Rezoning Transportation Analysis

Petition Number: 2022-219

Date	Description
4-26-23	First Review (IW)

RZ-1.0

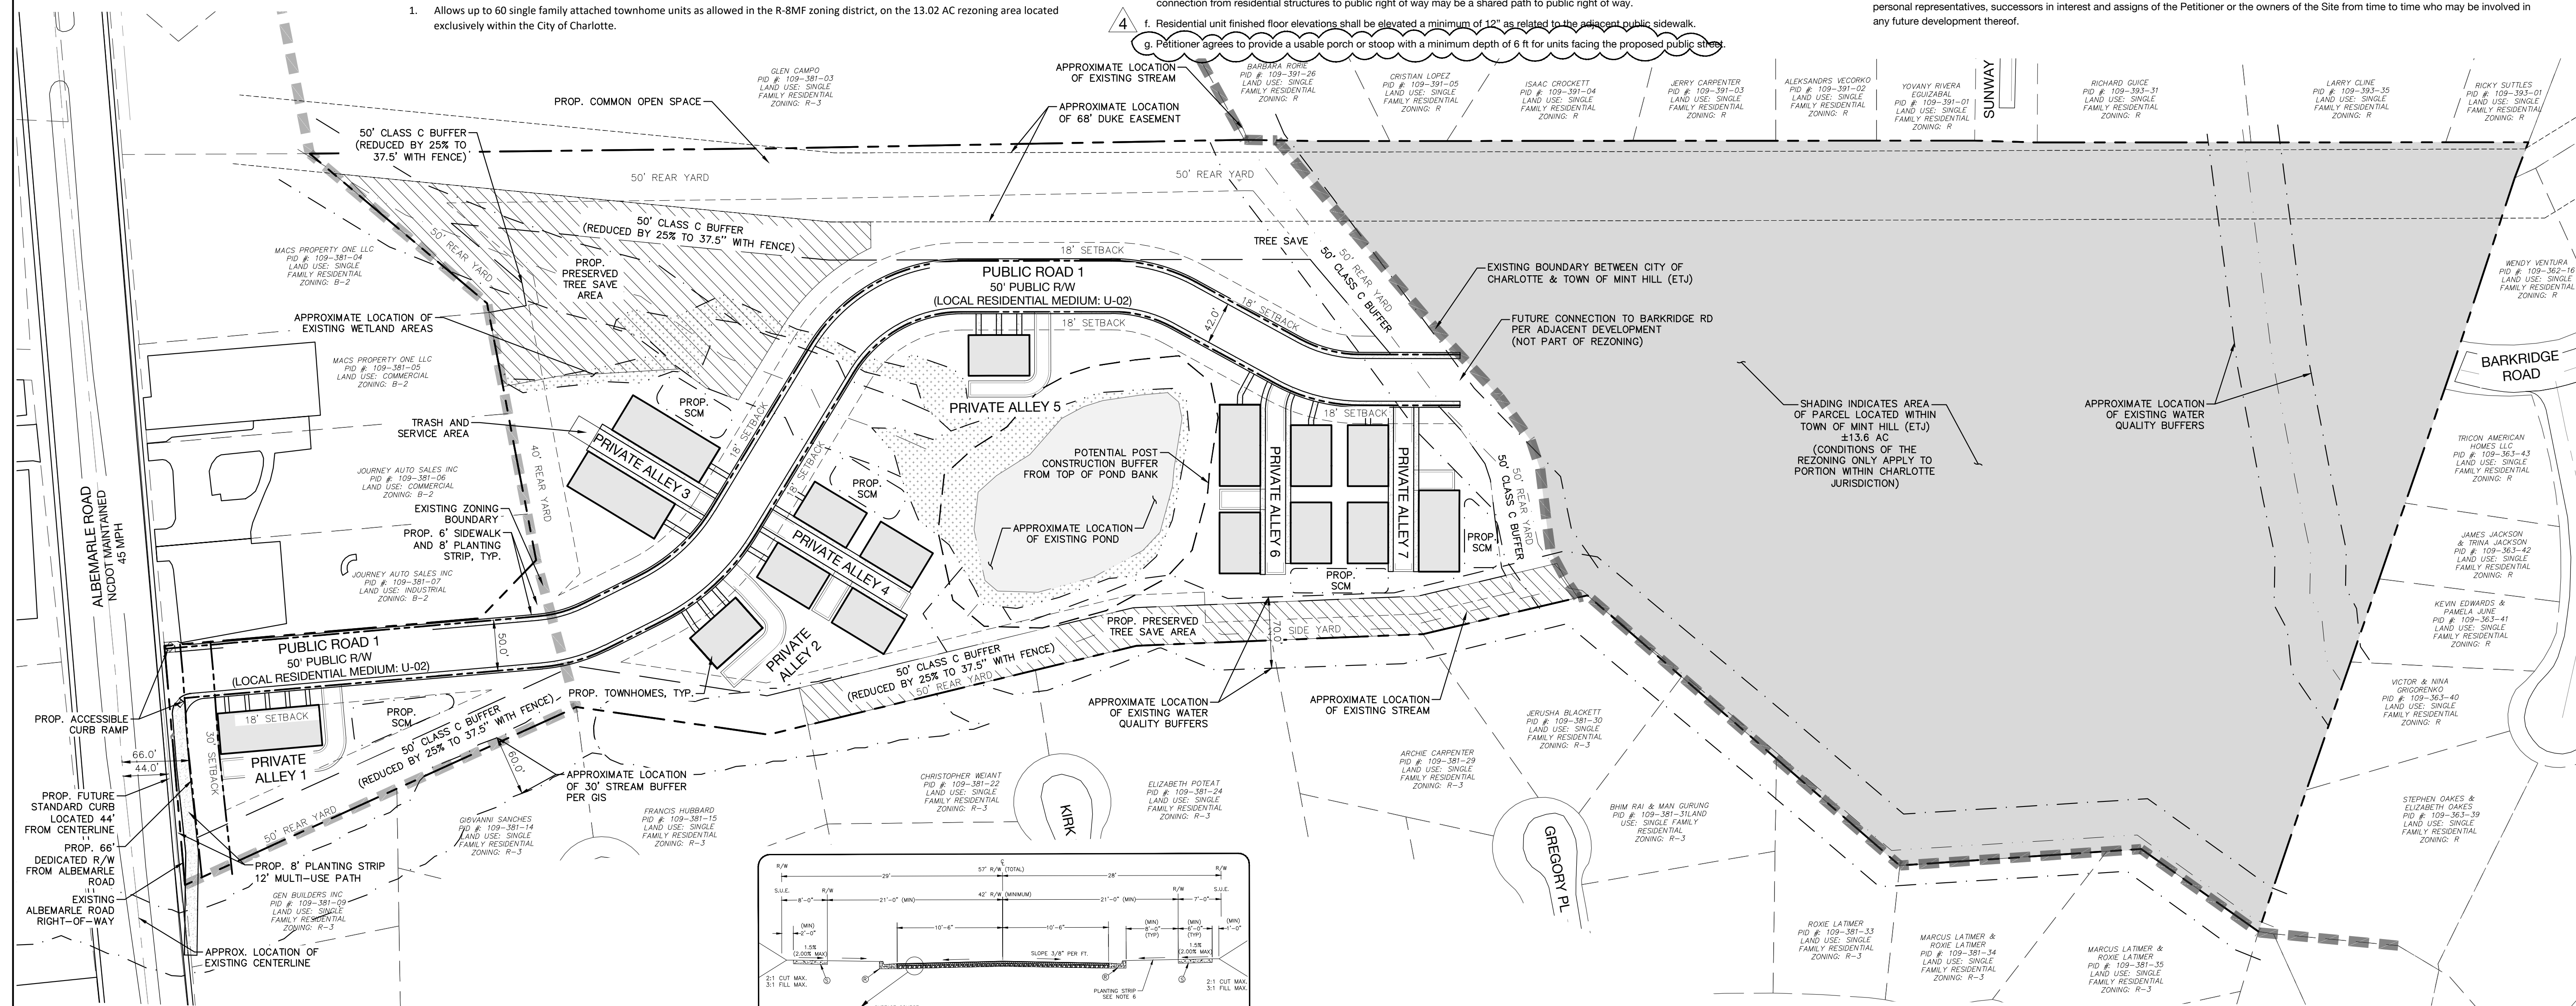
- a. **Albemarle Road:** Location of curb and gutter to be moved to 44 feet from roadway centerline to accommodate the Charlotte Streets Map with a roadway typical section of 6+ Boulevard with shared use path.

Label and dimension the curb and gutter from the centerline for each road on the site plan.

- 3. Revise site plan and conditional note(s) to commit to dedicate 66' right-of-way from the road centerline or 64' with a 2' SUE. The site plan shall label and dimension the right-of-way from the road centerline.

- 4. Revise site plan and conditional note(s) to commit to constructing an 8-foot planting strip, and 6-foot sidewalk on Public Road 1 per Chapter 20. The site plan shall label and dimension both items from the back of curb and gutter or edge of pavement.
Conditional note 4 under "Transportation" states a 6' sidewalk and 8' planting strip will be provided as generally shown on site plan, but it is not clear on the site plan where this streetscape will be. Please clearly show planting strip and sidewalk will be along Public Road 1.

- 5. Revise site plan and conditional note(s) to commit to installing the 8' planting strip and 12' multi-use path at the future location to meet the Council-adopted Charlotte BIKES Policy and Charlotte. Multi-use paths maintained by the City shall meet ADA/PROWAG requirements.

7. Revise site plan and conditional note(s) to commit to create access on alley for townhomes currently proposed to have driveways on Public Road 1.

8. CDOT requests petitioner revise site plan and conditional note(s) to commit to constructing a right turn lane on Albemarle Road per coordination with NCDOT due to volume and speed in this area of the city.

9. CDOT requests petitioner revise site plan and conditional note(s) to commit to building Public Road 1 to the Local Residential Wide Street Section (CLDSM U-03A).

10. Add a conditional note specifying "the Petitioner shall dedicate and convey in fee simple all rights-of-way to the City before the site's first building certificate of occupancy is issued. CDOT requests rights-of-way set at 2' behind back of sidewalk where feasible."
Update conditional note 5 under "Transportation" to have SUE 2' behind MUP instead of 1' as shown. 2' is necessary for the maintenance of the path.

12. Add conditional note specifying “All public roadway improvements will be subject to the standards and criteria of CDOT and NCDOT, as applicable, to the roadway improvements within their respective road system authority. It is understood that such improvements may be undertaken by the Petitioner on its own or in conjunction with other development or roadway projects taking place within the broad South Eastern Mecklenburg area, by way of a private/public partnership effort or other public sector project support.”
13. Revise site plan and conditional note(s) to better illustrate what conditional note 3 under “Transportation” is referencing. It states ADA ramps will be provided at the corner of Public Road 1 and Albemarle Road as illustrated but there is not illustration of this proposed improvement.
